H11/D39

**DRAINAGE REPORT
QUAIL & COORS
QUAIL ROAD N.W. & COORS ROAD N.W.
CITY OF ALBUQUERQUE, NEW MEXICO**

RE: REVISED DRAINAGE PLAN FOR DIAMOND SHAMROCK, INC. @ COORS &
QUAIL, NW (H-11/D39) REVISION DATED MAY 12, 1992

RE: DRAINAGE PLAN FOR DIAMOND SHAMROCK, INC. @ COORS &
QUAIL, NW (H-11/D39) ENGINEER'S STAMP DATED
JANUARY 21, 1992

H11/P39
GRADING AND DRAINAGE PLAN
STORE # 1219
QUAIL RD. & COORS RD.
ALBUQUERQUE, NEW MEXICO

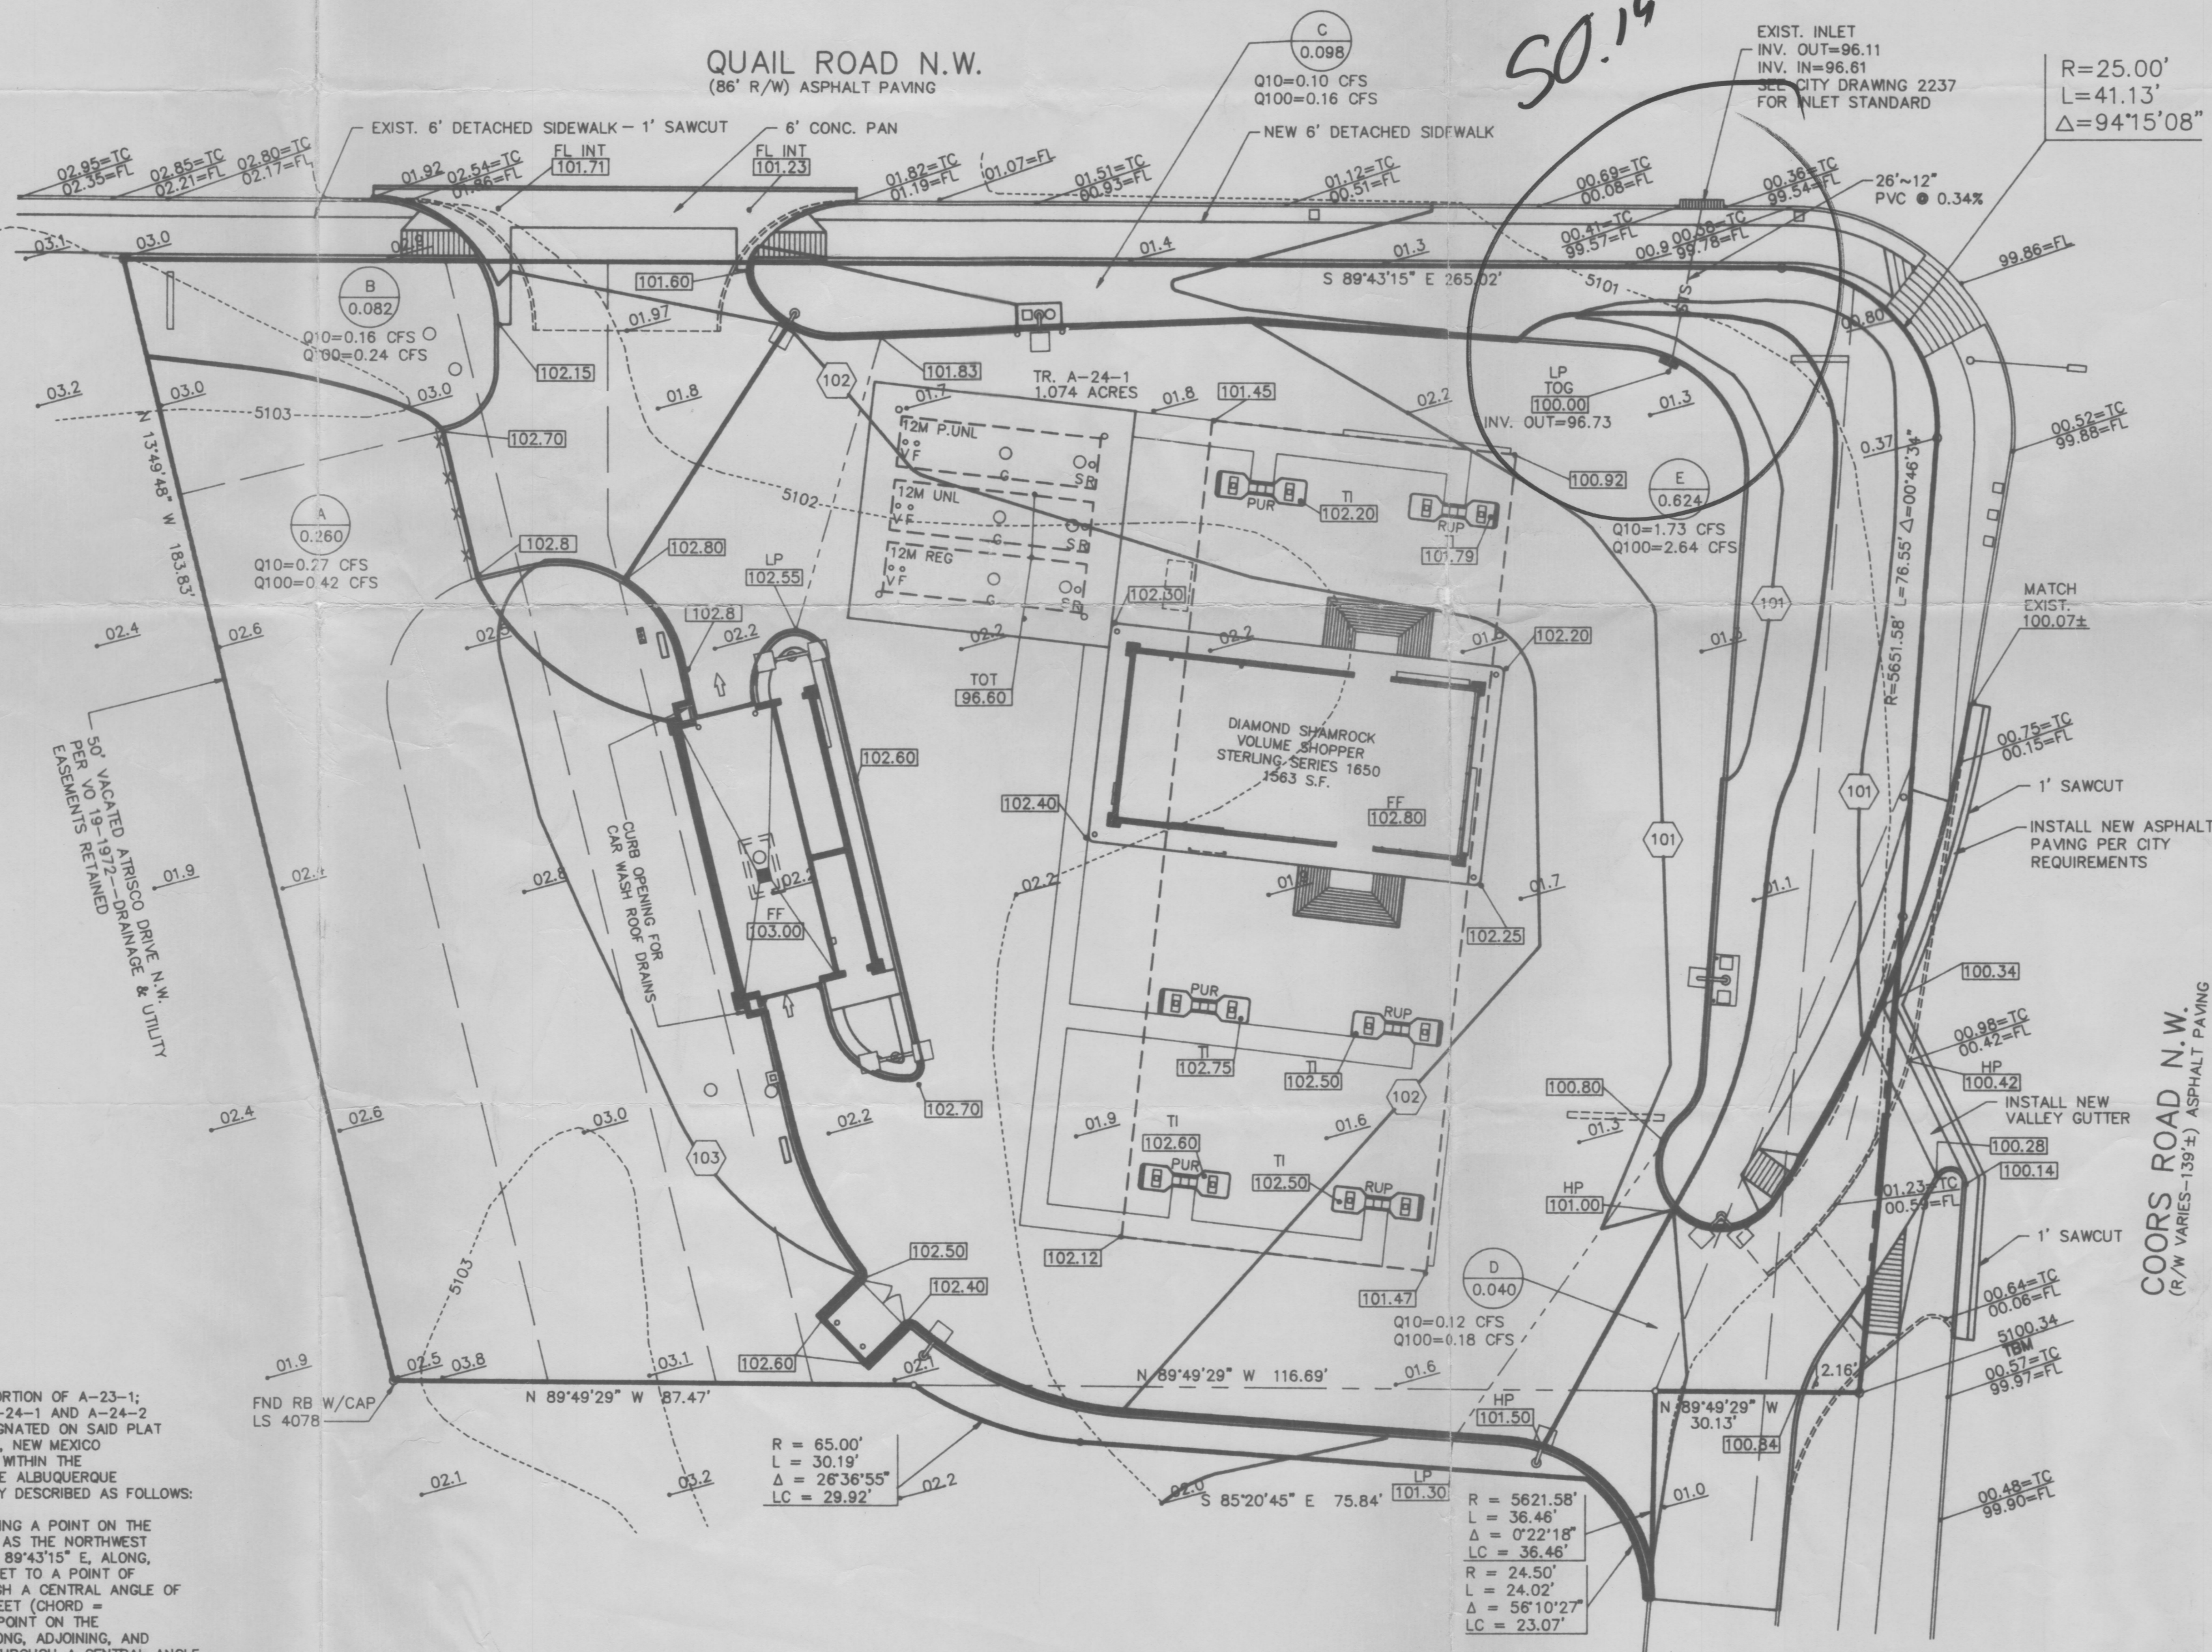
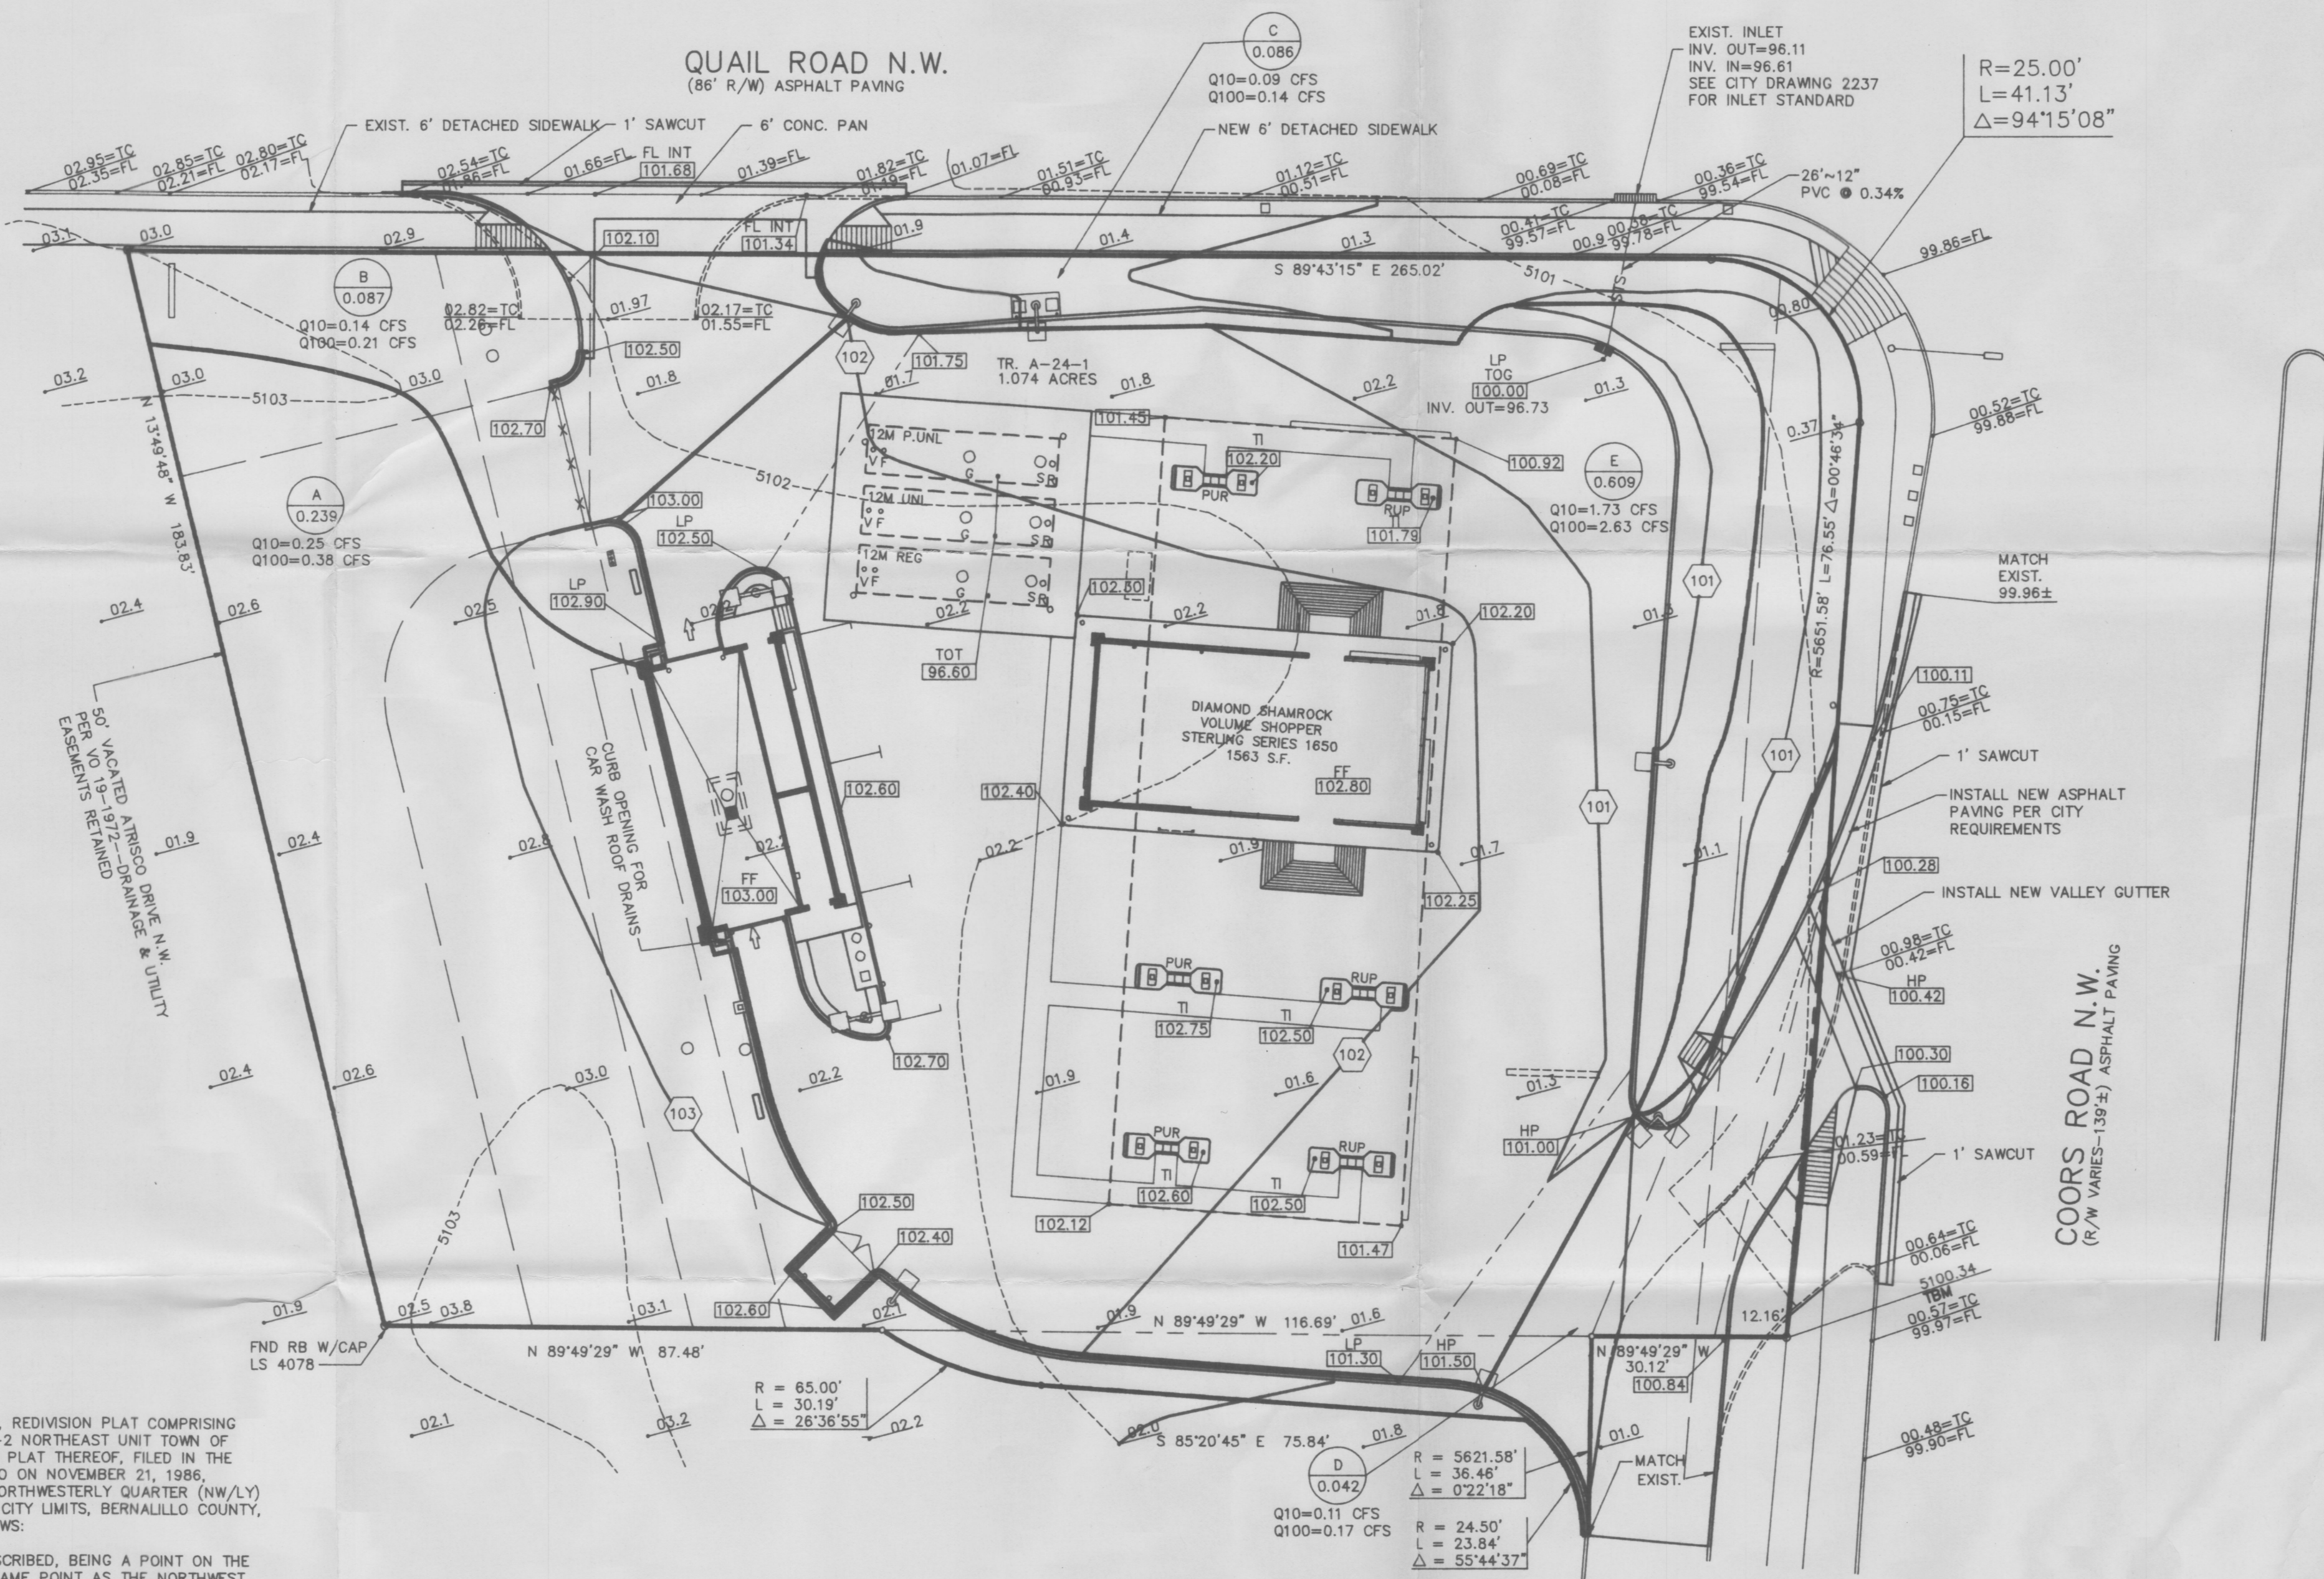
1. Your plan drawing indicates some work being proposed on the adjacent property to the south. We will need concurrence from the owner.
2. T.B.M. must be permanently marked.
3. Notation on plan that the roof drains from the car wash must be routed towards the asphalt.
4. Please include the hydraulics for the proposed inlet and pipes. Also, indicate the flow rate entering the proposed inlet.
5. On your resubmittal, submit only two copies of (SP-3). I do not need the report. You can add the hydraulics on the plan drawing.
6. Engineer's Certification will be required prior to release of Certificate of Occupancy. A field trip by someone from your company is required and not just the as-built information from the contractor is adequate for Certification.
